From: Thomas Callaway
Sent: 02 July 2015 15:14
To: Planning.Responses
Subject: RE: Planning Consultation on: FG/85/15/PL

APPLICATION **FG/85/15/PL**

Site Address: Onslow Caravan Park Onslow Drive Ferring BN12 5RX

Description of Works: Demolition of three buildings & erection of replacement workshop & machinery store (amended to FG/161/14/PL).

Sheet 2Fi - Proposed Block Plan
Scale 1:500 @ A3

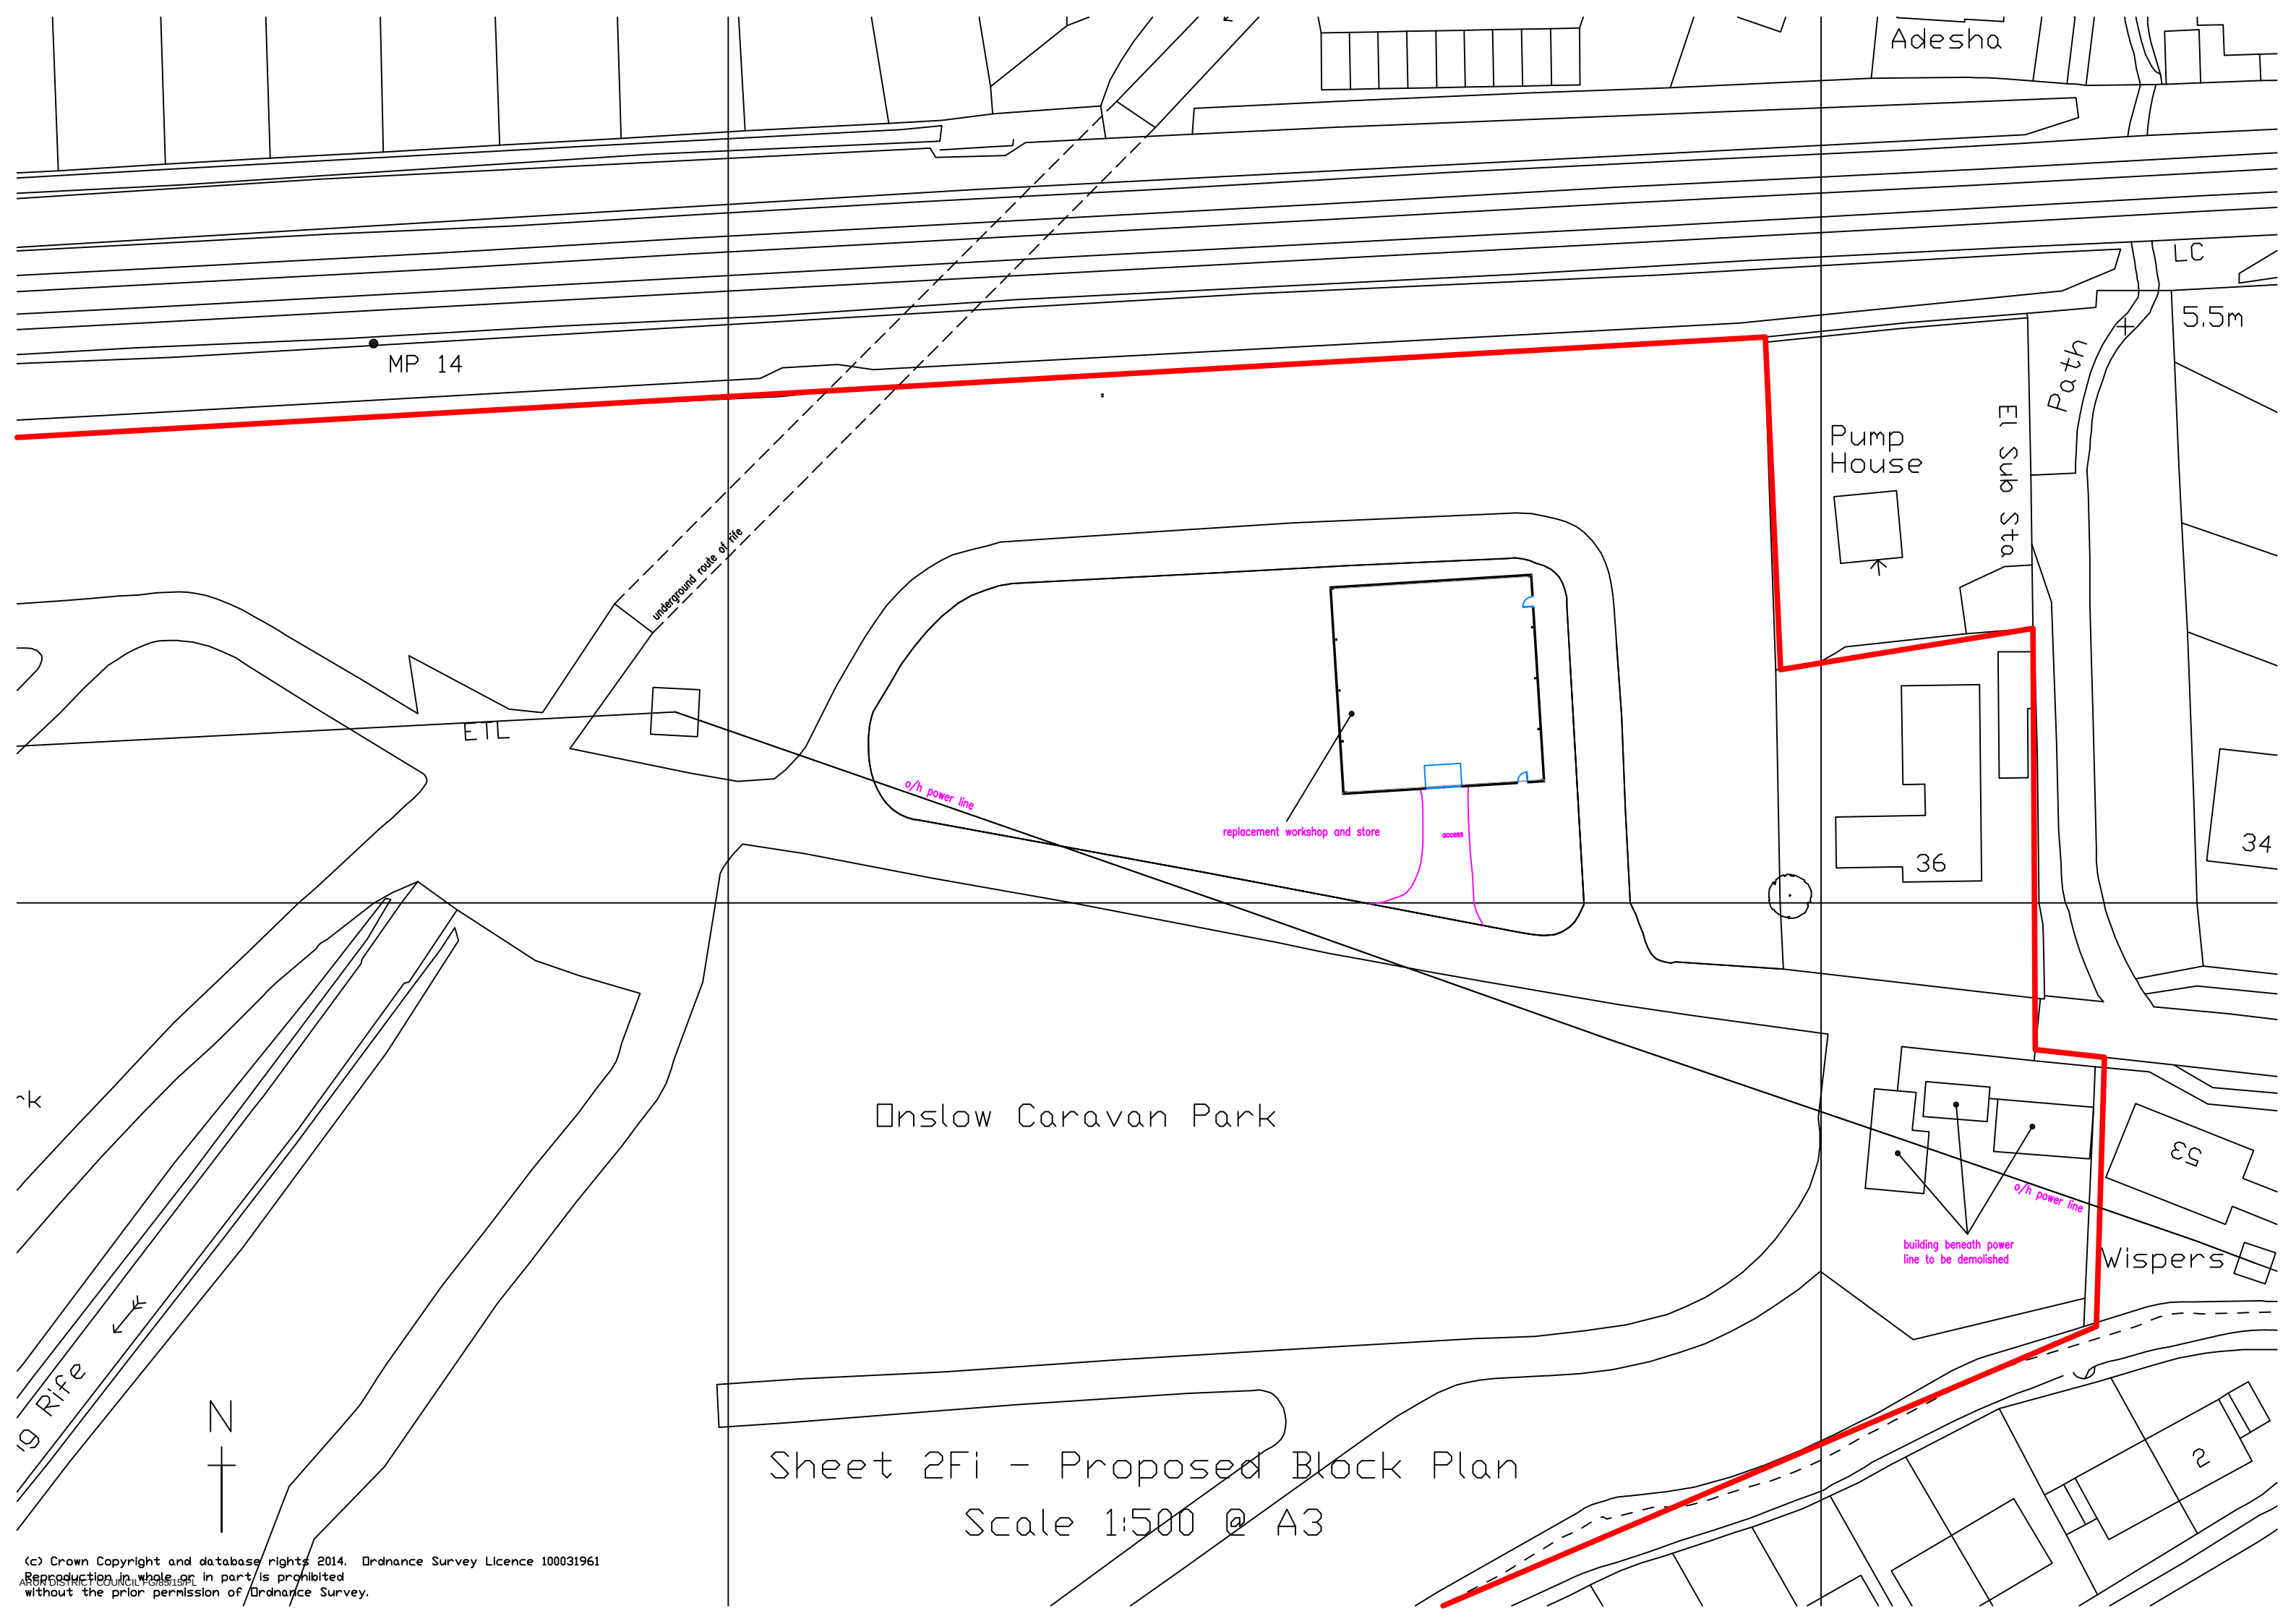
The issue regarding proximity to the watercourse has been resolved by relocating the proposed building.

Infiltration must still be investigated prior to discharging surface water to the watercourse.

Infiltration rates for soakage structures are to be based on percolation tests undertaken in the winter period and at the location and depth of the proposed structures. The percolation tests must be carried out in accordance with BRE 365, CIRIA R156 or a similar approved method and cater for the 1 in 10 year storm between the invert of the entry pipe to the soakaway, and the base of the structure. It must also have provision to ensure that there is capacity in the system to contain below ground level the 1 in 100 year event plus 30% on stored volumes, as an allowance for climate change. Adequate freeboard must be provided between the base of the soakaway structure and the highest recorded annual groundwater level identified in that location.

Any SuDS or soakaway design must include adequate groundwater monitoring data to determine the highest winter groundwater table in support of the design. The applicant is advised to discuss the extent of groundwater monitoring with the Council's Engineers. Supplementary guidance notes are also enclosed for information.
